RE: SSD 8209 – Oakdale South Stage 4 - Costco Wholesale, Site 4A Oakdale South.

Table 1 – Response to Submissions

02 LANDSCAPE SECTION 01
SECTION 1:200@B1

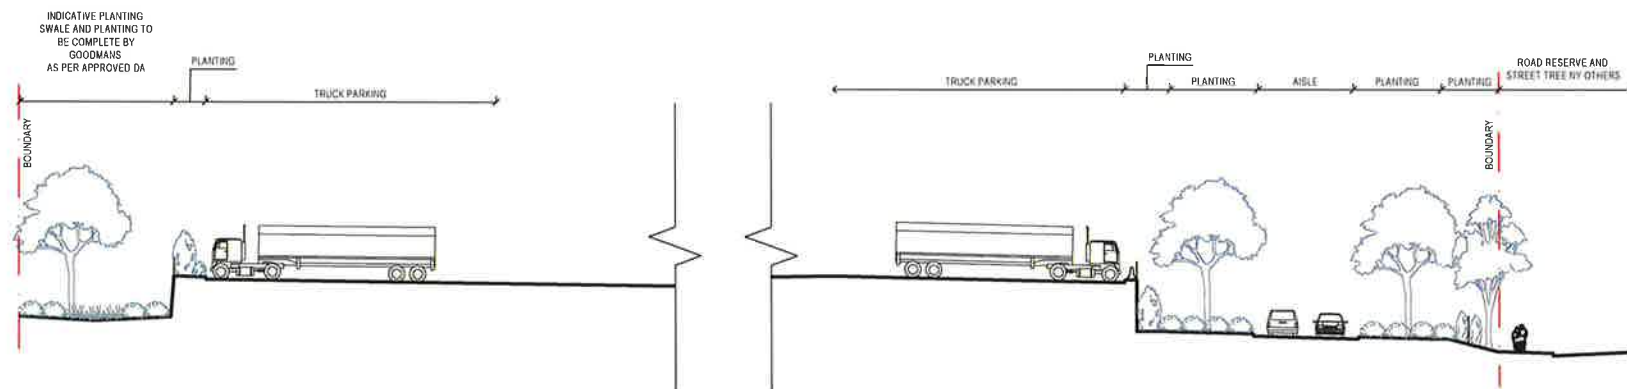
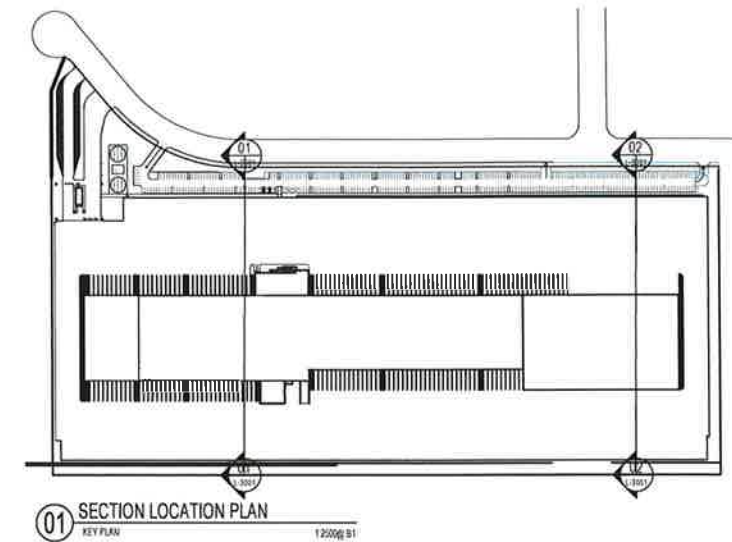
Matters Raised	Applicant consideration of matter/response
• Landscape cross-sections should be provided to understand the changes in the levels. • Perspectives should be provided from key locations, including from the rural- residential lands to the east, that accurately indicate the proposed landscaping. • No footpath is provided through certain sections of the car park. To ensure pedestrian safety, the footpath should be provided along the entire length. • Fencing details should be provided. Fences should be setback approximately 2m from the front boundary. • The northern boundary has an interface with open space riparian corridor. A greater diversity of tree species including larger tree species in the planting mix shall be provided.	the end of Estate Rd 01, its visibility is limited. Additional landscape screening is not feasible as the supply authority as strict setback requirements for vegetation. <u>Comment</u> – Landscape Cross sections cut through the south-east corner have been added to L-4001 to highlight the changes in the levels (Appendix E) <u>Comment</u> – We believe additional perspectives are not required since boundary treatments remains consistent with that approved under MOD1 SSD6917. It should be noted that Visual Impact Assessment, approved under MOD1 of SSD6917, took into account the visual impact of the proposed Lot 4 building from various key vantage points, including from the rural residential land to the east. A supplementary section has shown on Landscape Drawing L-4001 attached assist in illustrating the relationships between levels, acoustic wall, retaining wall and Costco vehicular concourse <u>Comment</u> – Costco propose a one metre wide zebra line marked path along the length of the carpark in the north-south axis to address any concerns of safety within this staff carpark <u>Comment</u> – Refer to attached updated supplementary landscape plans (Appendix E) which includes fence details on L-4001. The fence needs to be on the front/street boundary to demarcate the estate and on-lot landscape areas, which is subject to different maintenance regimes. <u>Comment</u> – the plans have been updated (Appendix E) to includes greater mix of plant species and demonstrate greater consistency with plant selection in the approved SSD6917 landscape concept plan

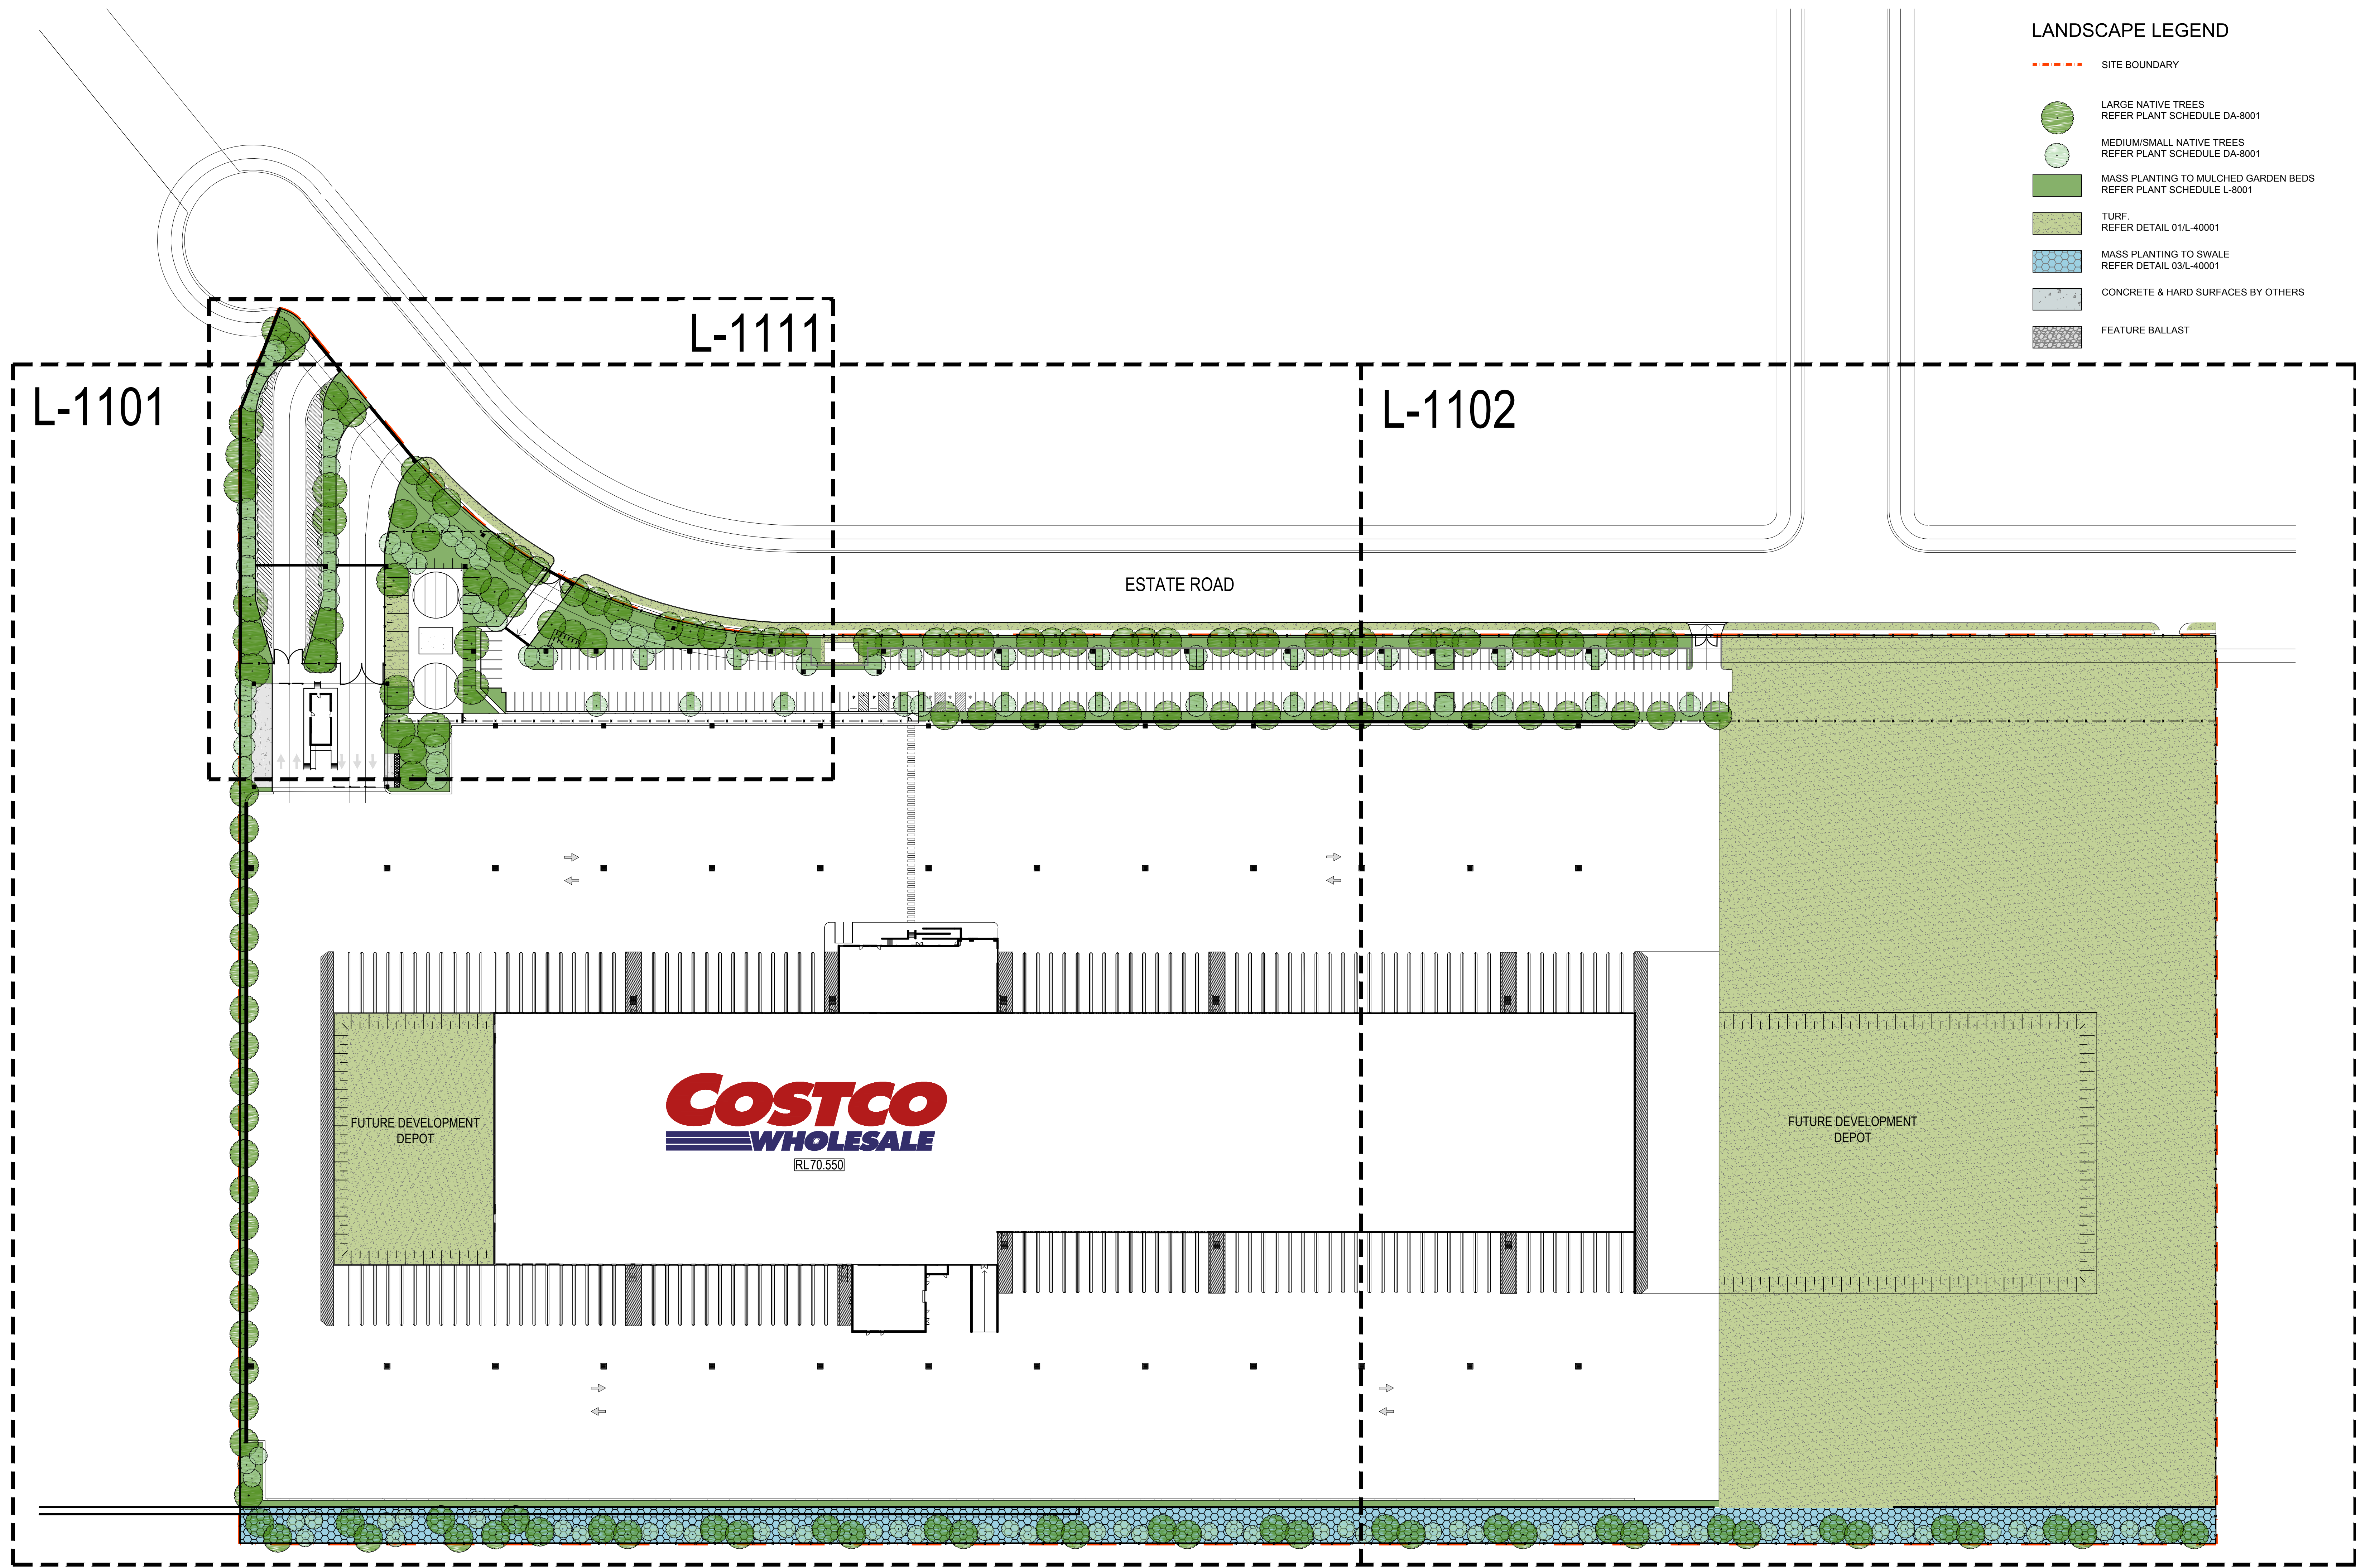
Matters Raised	Applicant consideration of matter/response
<u>Stormwater Management</u> - Please confirm the height of the water tanks and pump room fronting estate road 1. <u>Landscaping and Visual</u> - As noted by Penrith City Council, buffer landscaping treatments depicted in the landscaping plans are inconsistent with the landscaping approved under SSD 6917. Please provide landscape plans demonstrating consistency with the SSD 6917 landscape works. - Please provide a visual assessment of the water tanks and pump room when viewed from estate road 1 with landscaping that can be reasonably expected upon planting.	<u>Comment</u> – Group GSA have confirmed both water tanks are 4.76 metres high with a 12 metre diameter. The Pump Room is 3.4 metres high. <u>Comment</u> – Group GSA have revised the landscape plans to demonstrate consistency with the SSD 6917 landscape works. Refer to attached revised Landscape Drawings L-1000, L-1000.1, L-1101, L-1102.1, L-1102, L-1111 and L-4001 <u>Comment</u> – Group GSA advised that the perspectives provided with the SSD submission were created capturing the site entrance/arrival area including the water tank locations (Refer to Architectural Drawing DA8300, Appendix A). This perspective is an accurate representation of landscape species as proposed in Landscape documentation at year 5. An additional perspective (refer to Appendix B) has been prepared to provide a visual assessment of the water tanks and pump when viewed from estate road 1 with landscaping that can be reasonably expected upon planting. Below are the reasons why we believe the visual impact of the water tanks and pump room are acceptable: - The water tanks are 4.76m and the pump room is 3.4m are low in height which ensures that these structures will have a neutral impact on when viewed from estate road 1, noting this is a cul de sac. - The landscaping provided upon planting is dense.

Matters Raised	Applicant consideration of matter/response
• The landscaping should be amended to include shrubs. Fast growing shrubs (i.e. Wattles) should be considered to provide screening in the medium term while other landscaping is being established. • Insufficient landscaping is provided to the western end of the retaining wall located between the carparks. • Street trees are to be provided in accordance with the approved street tree masterplan (including layout and other materials). • The hard stand area to the west of the building appears excessive. This area should be reduced to allow for greater landscaping between the car park areas.	<u>Comment</u> – The landscape plan has been updated (Appendix E) the visual impact of the proposed retaining wall is significantly less intrusive than if the warehouse to be located close to the boundary. The retaining wall, with the proposed landscaping treatment presents well to the Estate Road 1. It should also be noted that as the exposure of this portion of Estate Rd 1 will be limited as is towards the end of the road / cul de sac.] <u>Comment</u> – the landscape plans have been updated (Appendix E) to ensure that proposed street trees reflect that approved under SSD6917 landscape masterplan. Note however Costco SSD scope of works apply to on-lot landscaping, not estate masterplan landscaping. <u>Comment</u> – The size of the hardstand area is a Costco operational requirement, as advised by the Traffic Engineer to enable adequate manoeuvrability for B-Double Trucks – this facility is a distribution depot. If the vehicular concourse area in front of the building or behind the building was any smaller, it would not comply with code requirements for vehicular movements. It should be noted that the proposed building footprint and hardstand layout is consistent with that approved under the SSD6917 concept approval.
